Rezoning Transportation Analysis

Petition Number: #2022-030

Date	Description
07-24-2022	First Review (AO)
09-21-2022	Second Review (AO)

800 MATHESON AVE - REZONING
 PARCEL ID 0811127
 800 MATHESON AV CHARLOTTE NC 28205
SITE PLAN - REZONING

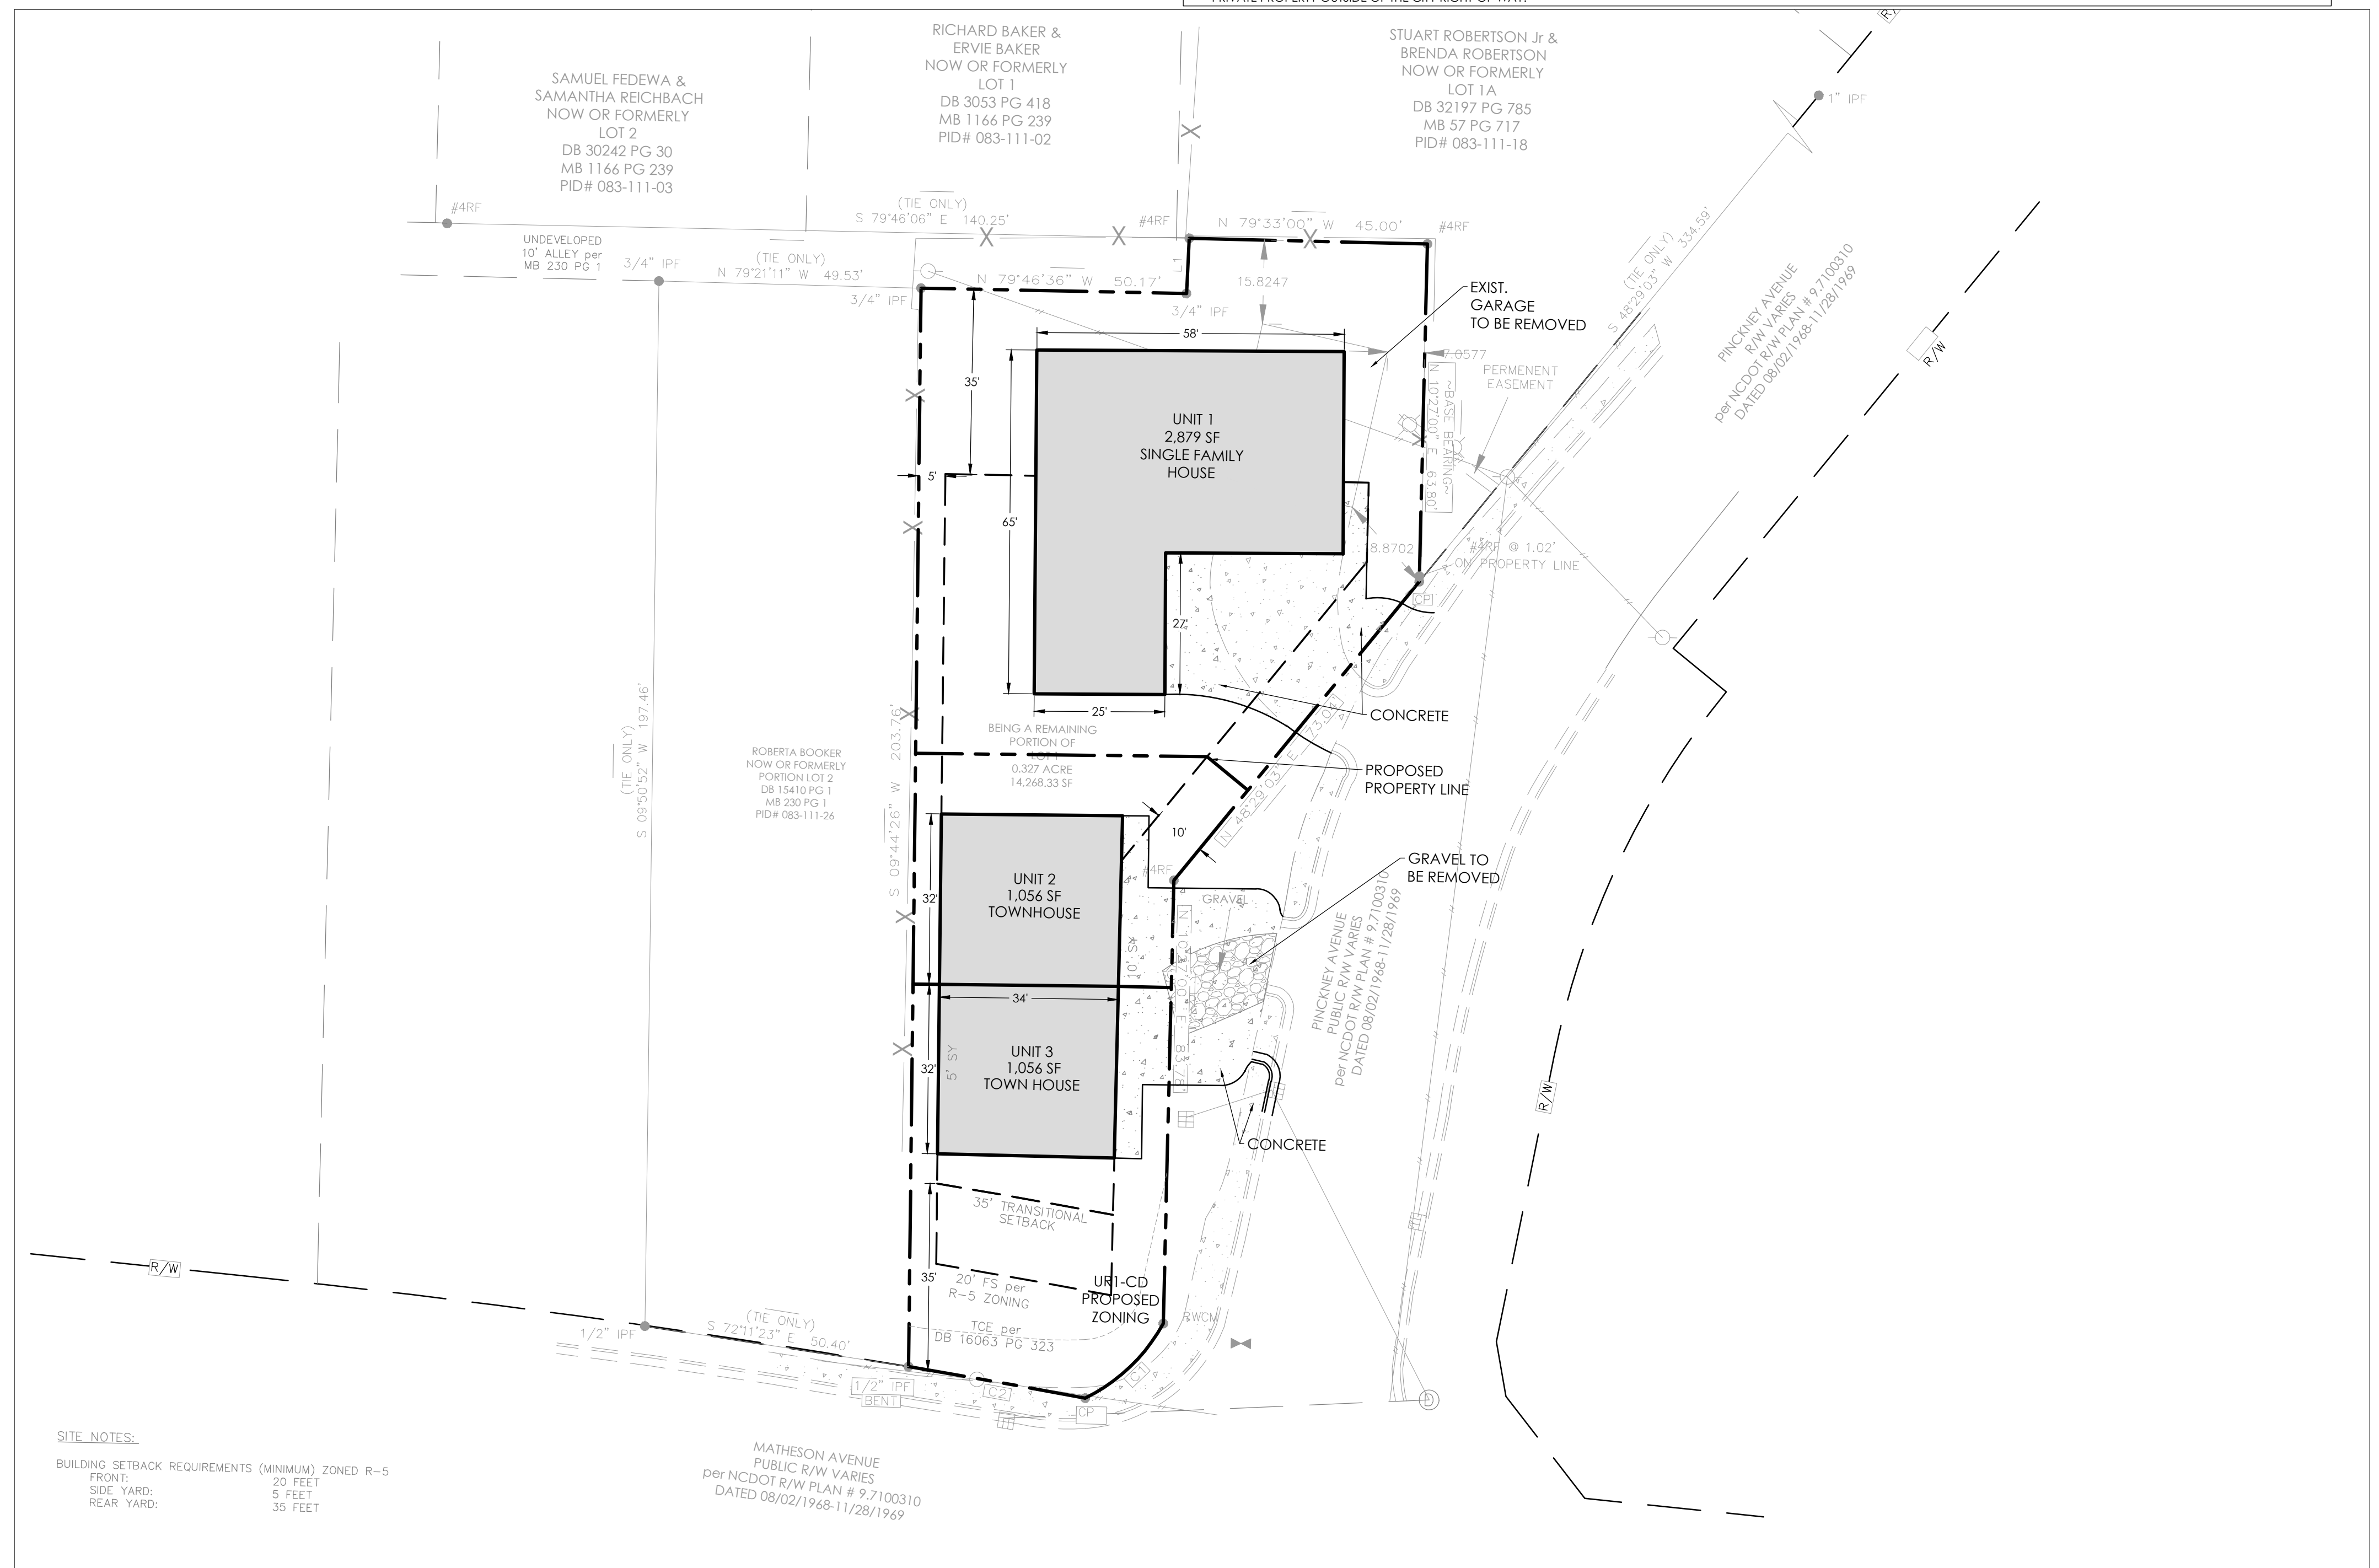
1. **Curblines:** The proposed zoning district has a setback measured from back of the existing or proposed future curblines.
 - a. **Matheson Avenue:** Curb and gutter to be 27-feet measured from centerline to back of curb.

Label and dimension the curb and gutter from the centerline for each road on the site plan.

Update to Comment (New Site Plan, 8-1-22): Label and dimension existing curblines location on site plan measured from centerline of Matheson Avenue.

3. **Outstanding Comment from 07-24-22:** Revise site plan and conditional note(s) to commit to dedicate 40-feet of right-of-way along Matheson Avenue measured from the road centerline. The site plan shall label and dimension the right-of-way from the road centerline.

4. Revise site plan and conditional note(s) to commit to construct an 8-foot planting strip, and 6-foot sidewalk on Matheson Avenue and Pinckney Avenue per Chapter 19. The site plan shall label and dimension both items from the back of curb and gutter.

Update to Comment (New Site Plan, 8-1-22): Add streetscape commitments to conditional notes section of the Rezoning Plan.

5. **Outstanding Comment from 07-24-22:** Revise site plan and conditional note(s) to show proposed intersection and frontage improvements of Matheson Avenue Road Conversion project project that is being done by the City's CIP project. These improvements can be shown as "by others" and in grayscale. The project scope includes converting Matheson Avenue from 4 lanes to 2 lanes, construct raised 2-way cycle track on south side of Matheson Avenue.

9. **New Comment (New Site Plan, 8-1-22):** Remove CDOT Notes from site plan.

10. **New Comment (New Site Plan, 8-1-22):** Revise conditional note 5.A) by replacing NCDOT with CDOT as Pinckney Avenue is City-maintained.
